Planning Inspectorate

Our Ref: EN010162

Application by Elements Green Trent Limited for an order granting development consent for the Great North Road Solar and Biodiversity Park

Advice following issue of decision to accept the application for examination

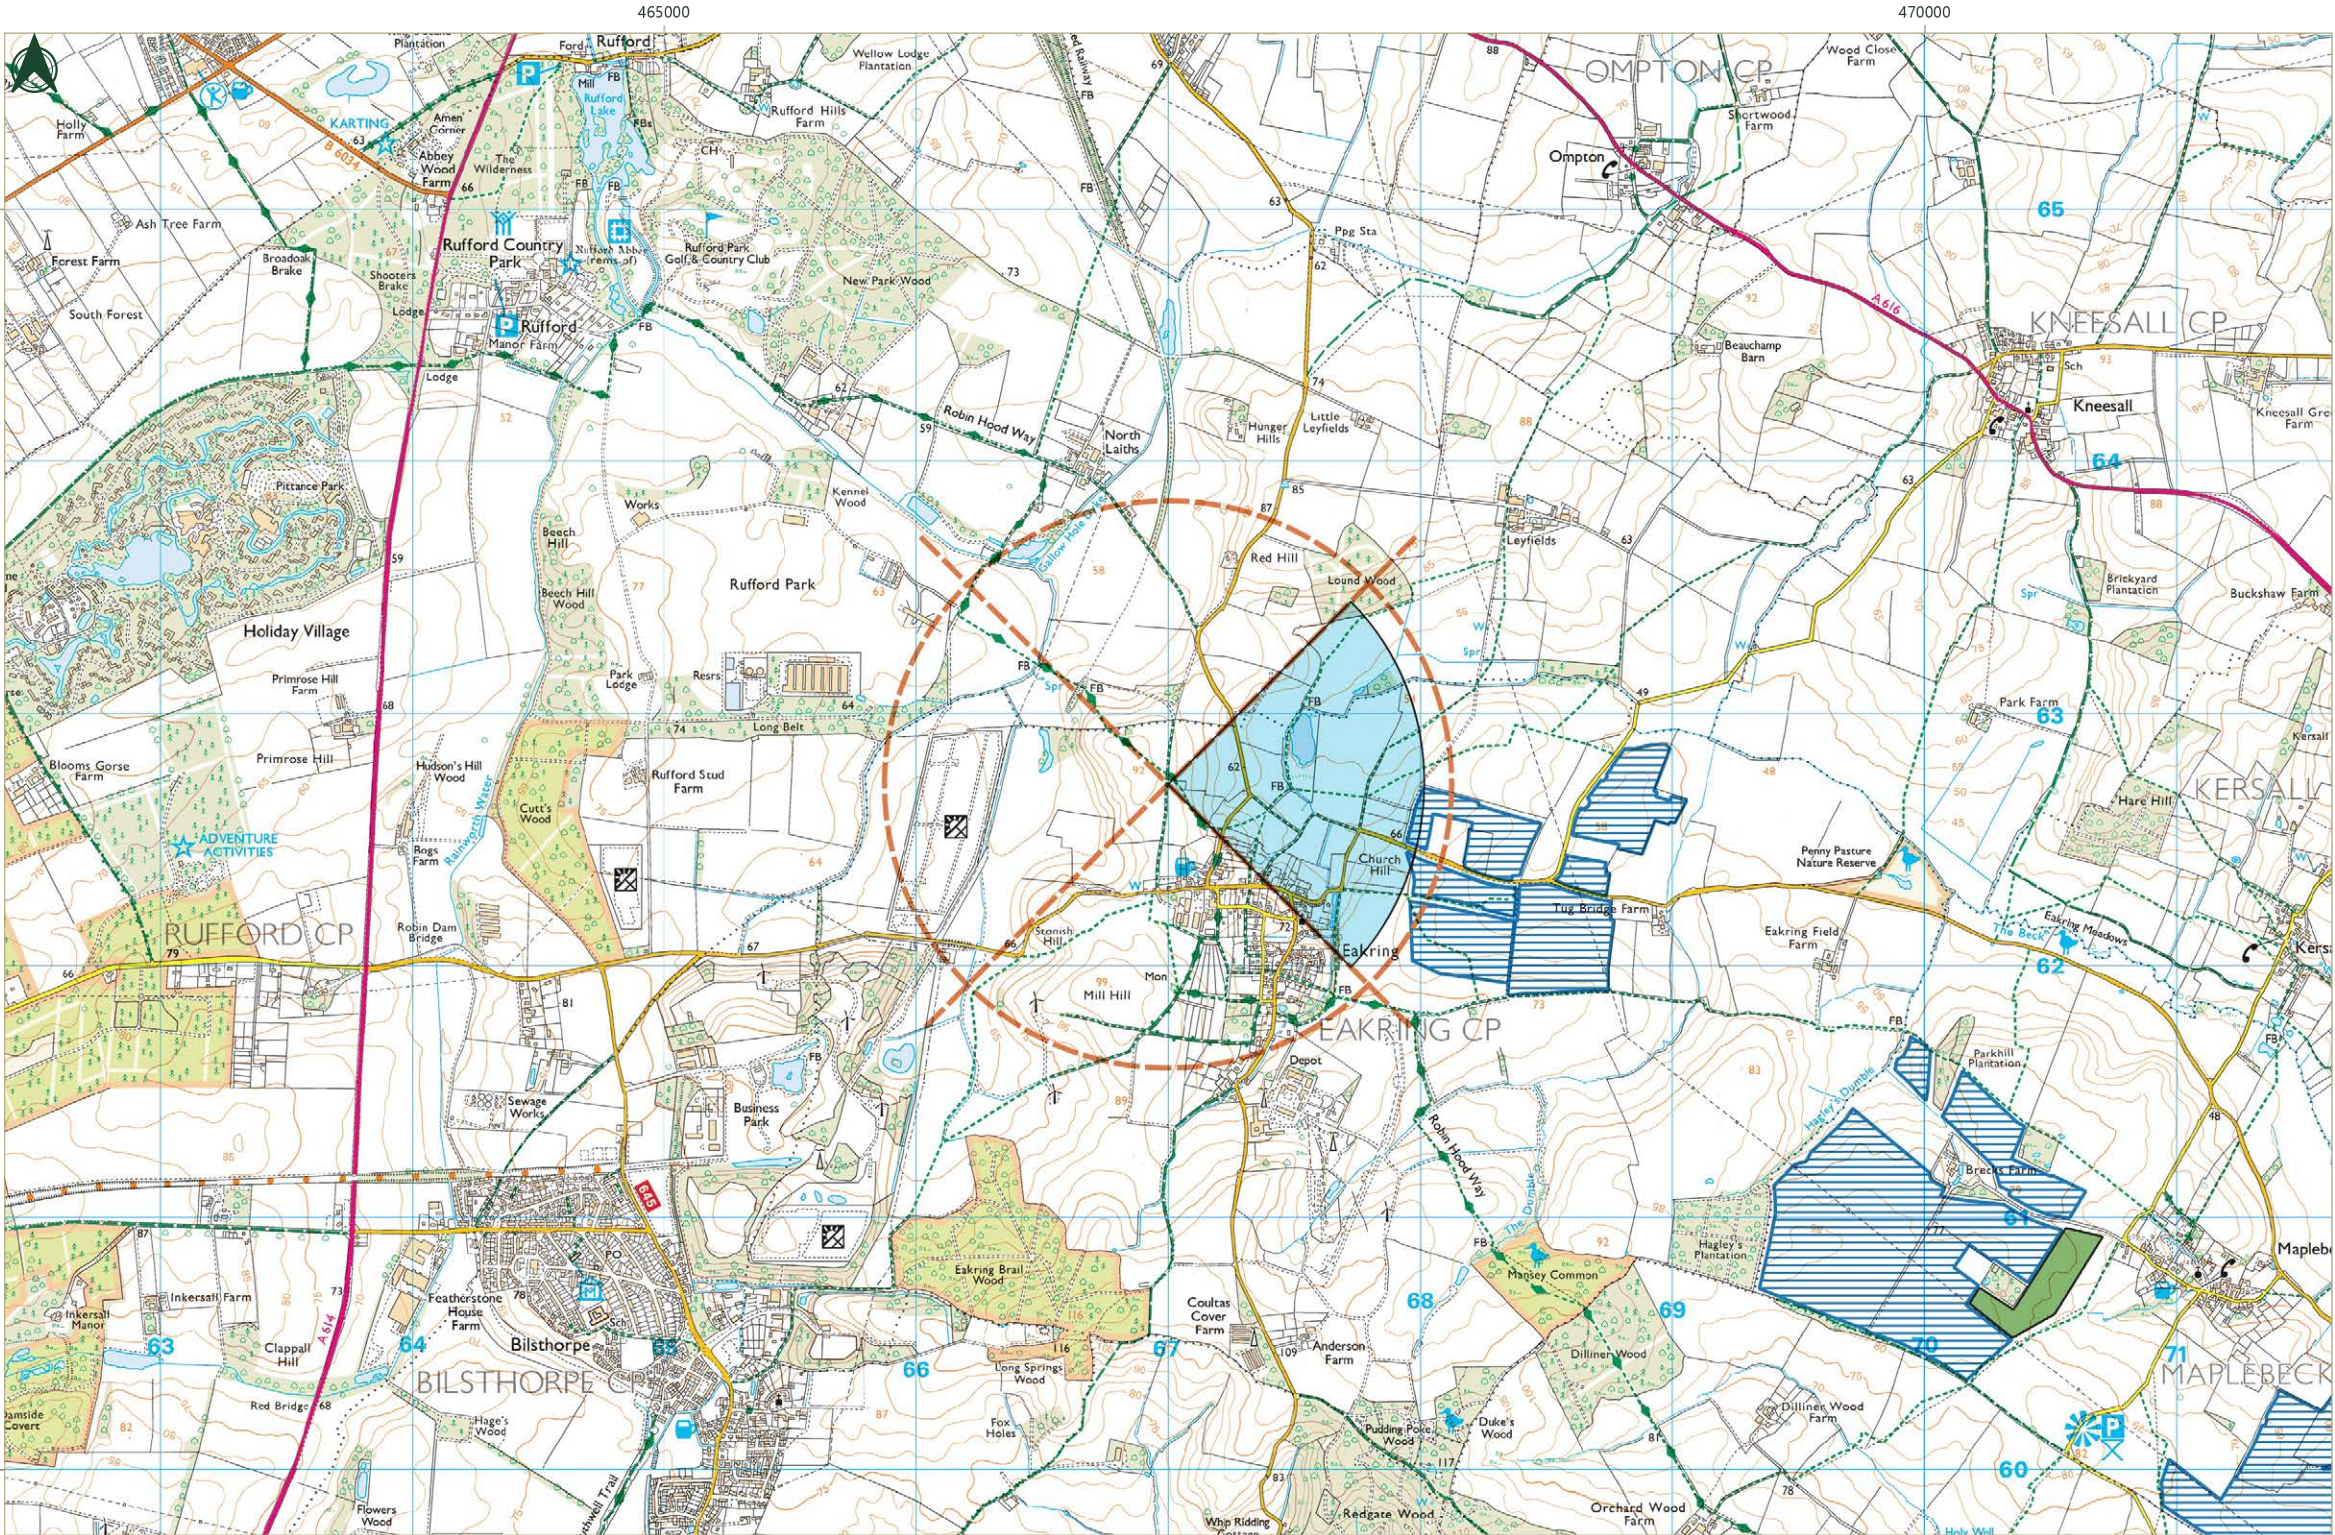
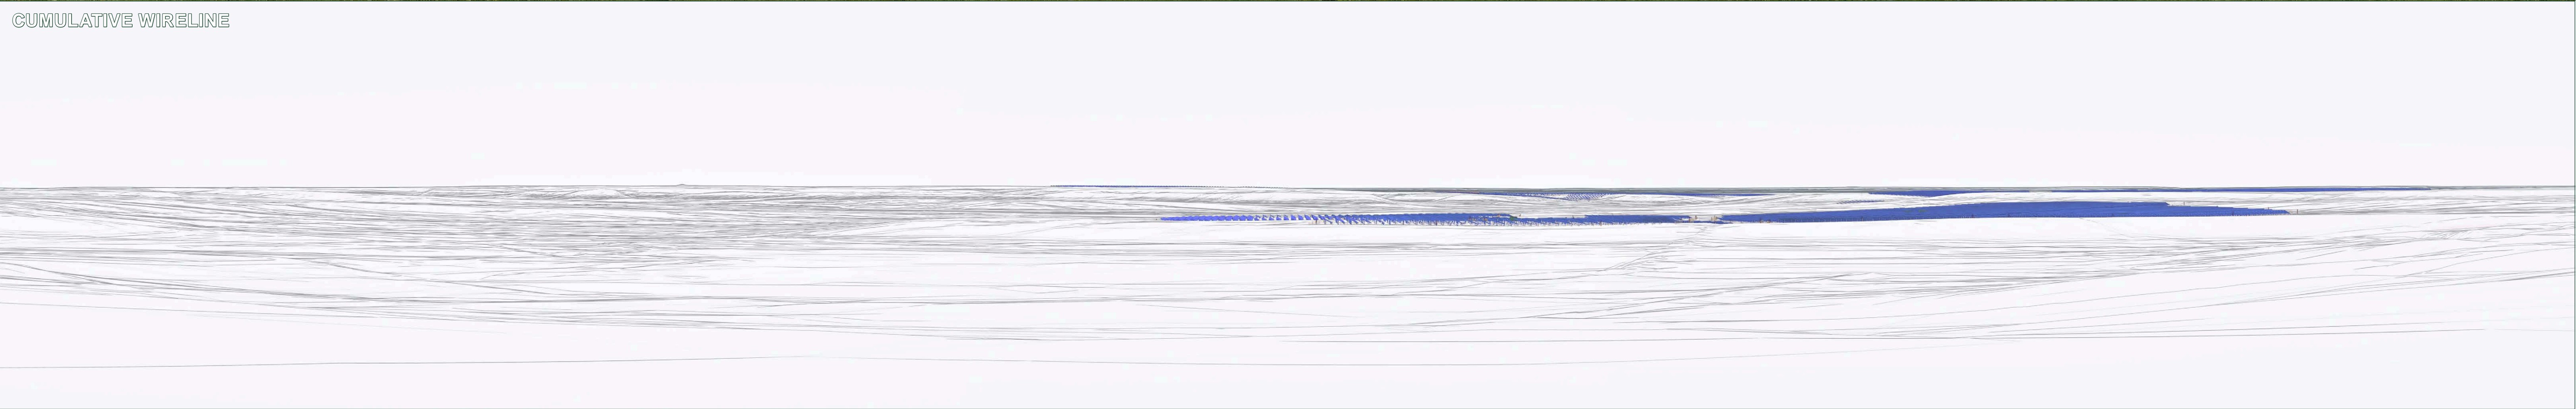
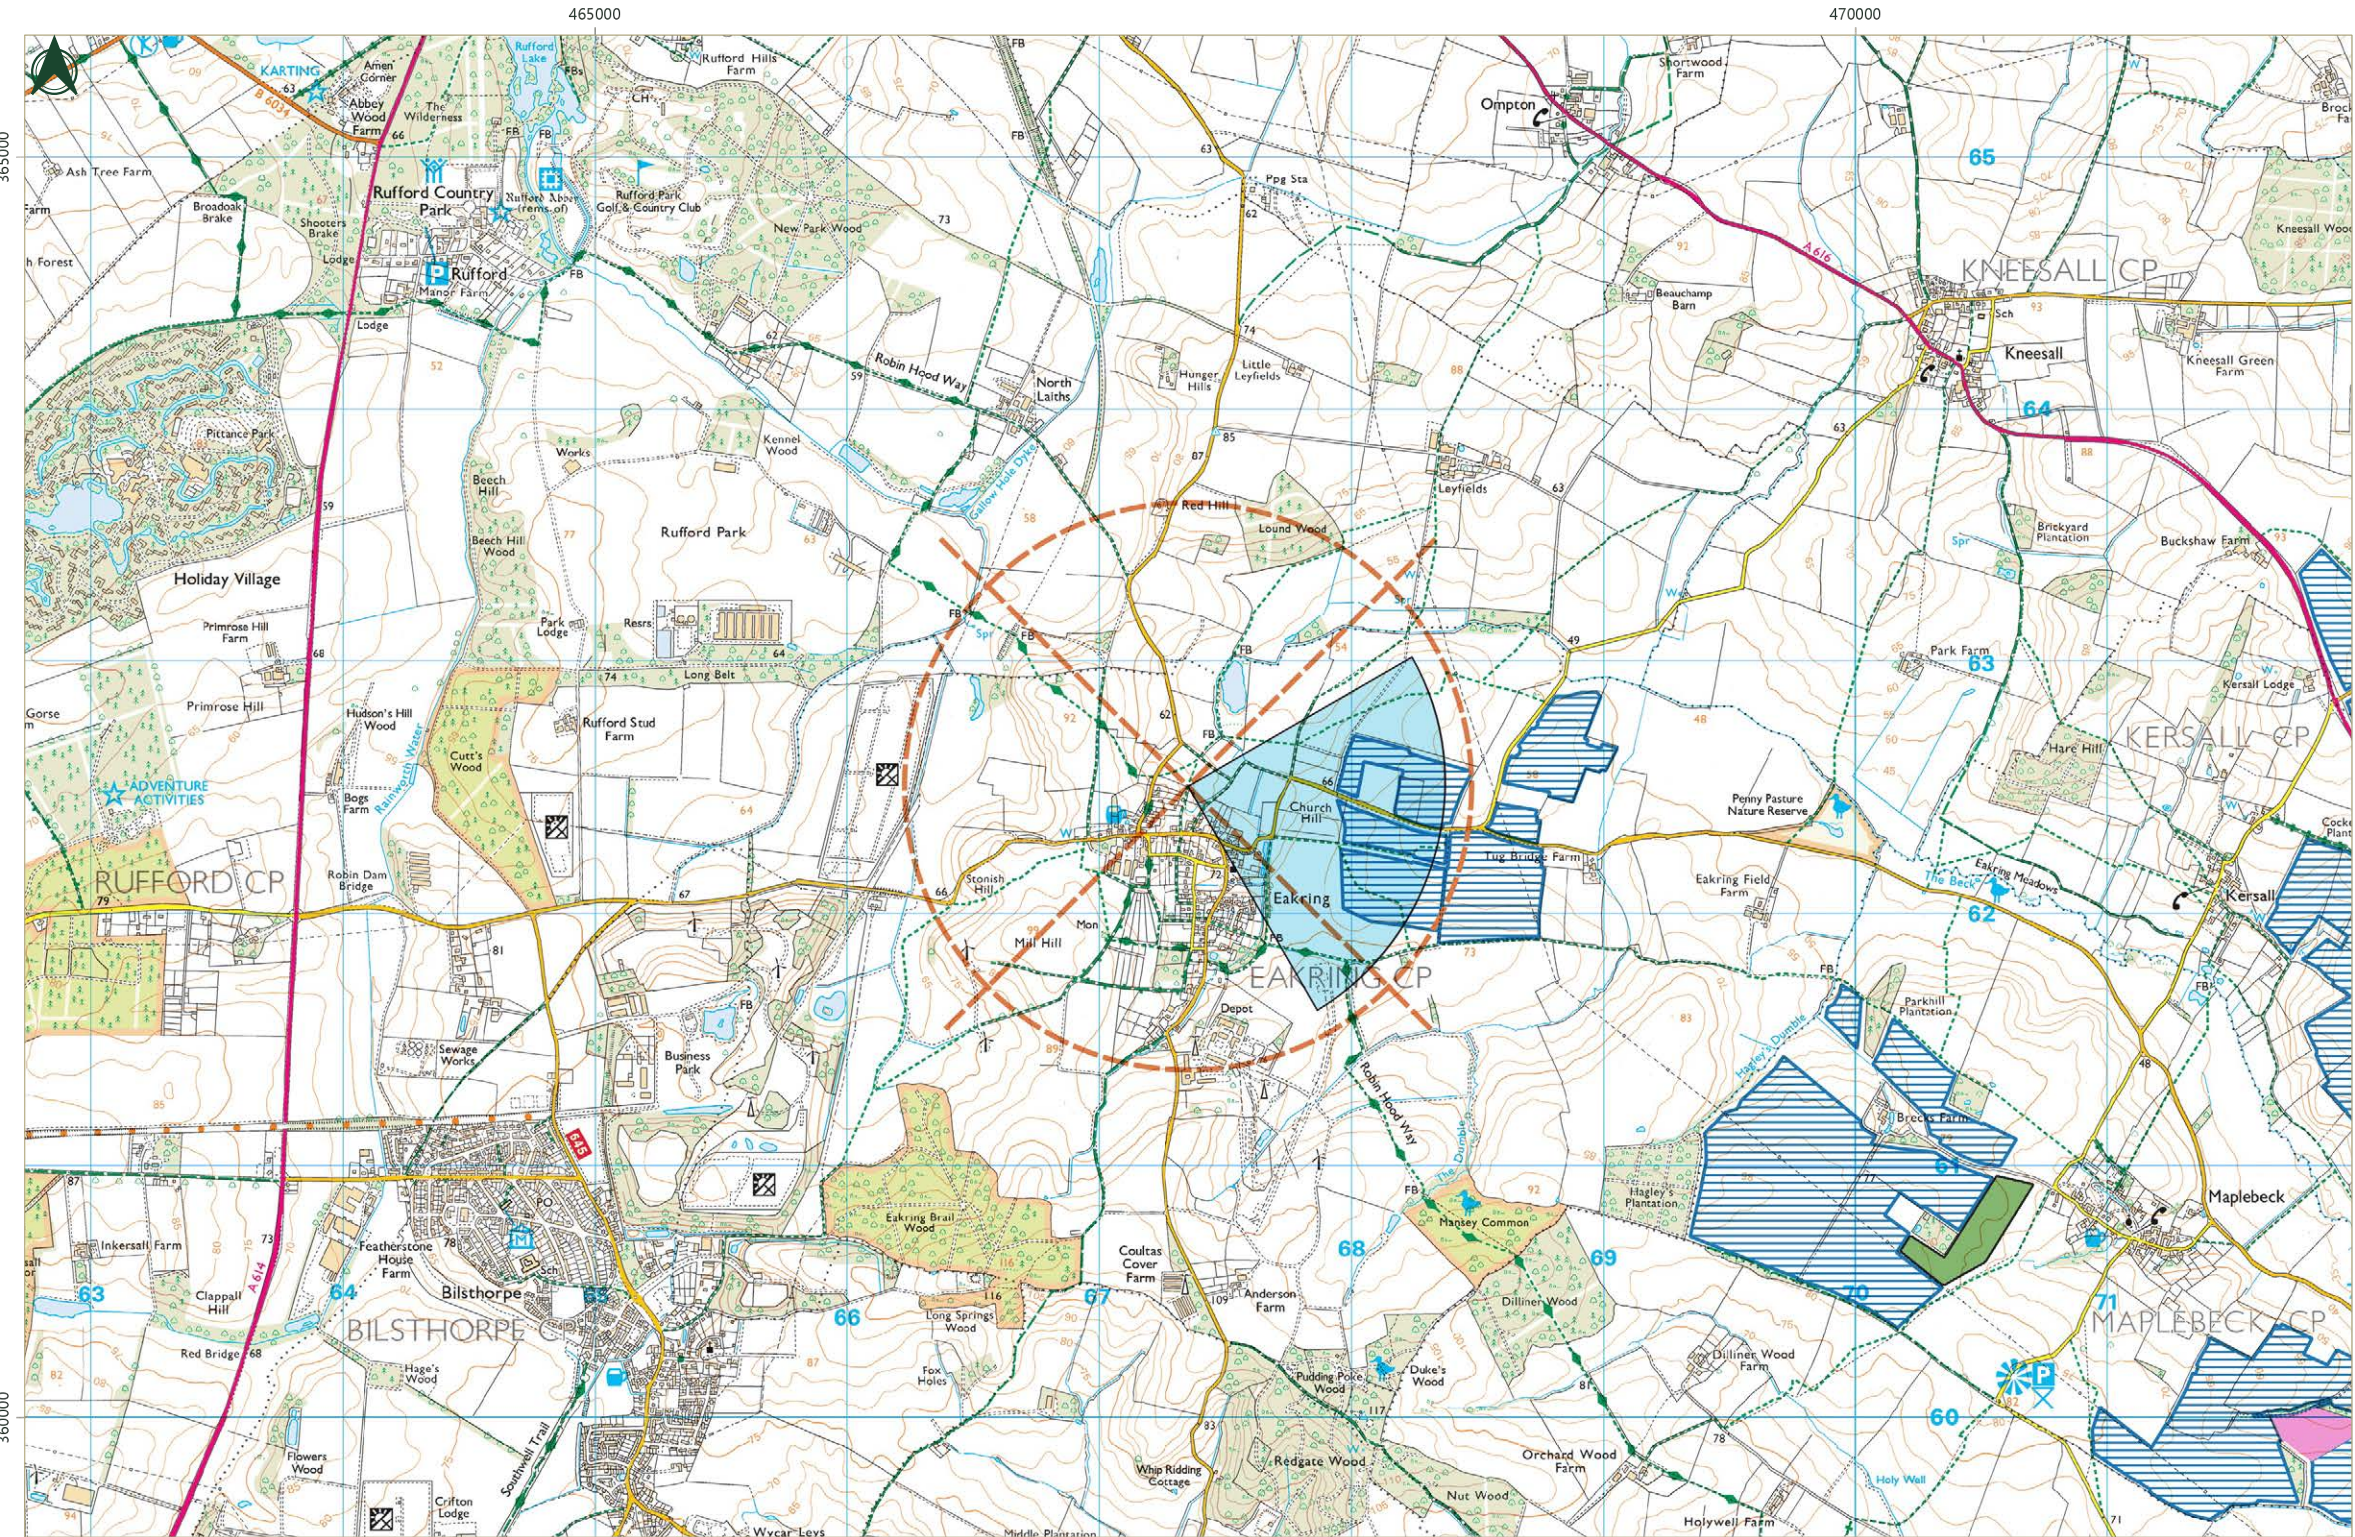
Environmental Statement (ES), Chapter 7, figures 6.3.7.11.1 – 6.3.7.11.55

The Landscape and Visual Impact Assessment (LVIA) contained within the ES, Chapter 7 details the analysis undertaken for 55 viewpoints from the visualisations contained within figures 6.3.7.11.1 – 6.3.7.11.55. The technical appendix detailing the methodology also refers to photomontages and wireline modelling where required.

However, the visualisations and photomontages do not appear to have been provided, as figures 6.3.7.11.1 – 6.3.7.11.55 contain only the location plan of the viewpoint as well as its description. We request that the applicant provide these visualisations and photomontages ahead of the opening of the relevant representation period.
